CITY OF ALBUQUERQUE

**Re: Reginald Chavez Elementary Portables
Grading and Drainage Plan
Engineer's Stamp Date 8-4-14 (J12D009)**

EROSION SEDIMENT CONTROL PLAN  
SUPPLEMENTAL SITE AND DRAINAGE INFORMATION  
PORTABLE CLASSROOM RELOCATIONS  
REGINALD CHAVEZ ELEMENTARY SCHOOL

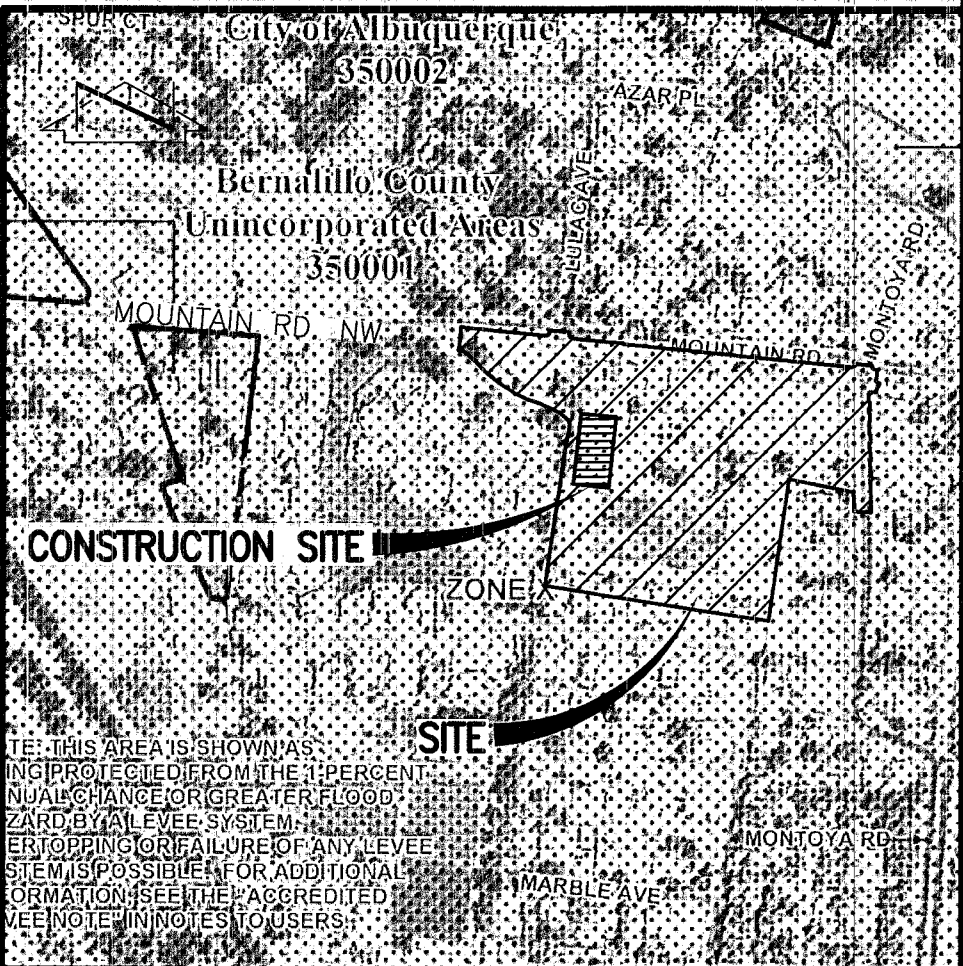
1. Provide a FIRM Map on sheet 1 of 1 that has a legible description which is not cut off.
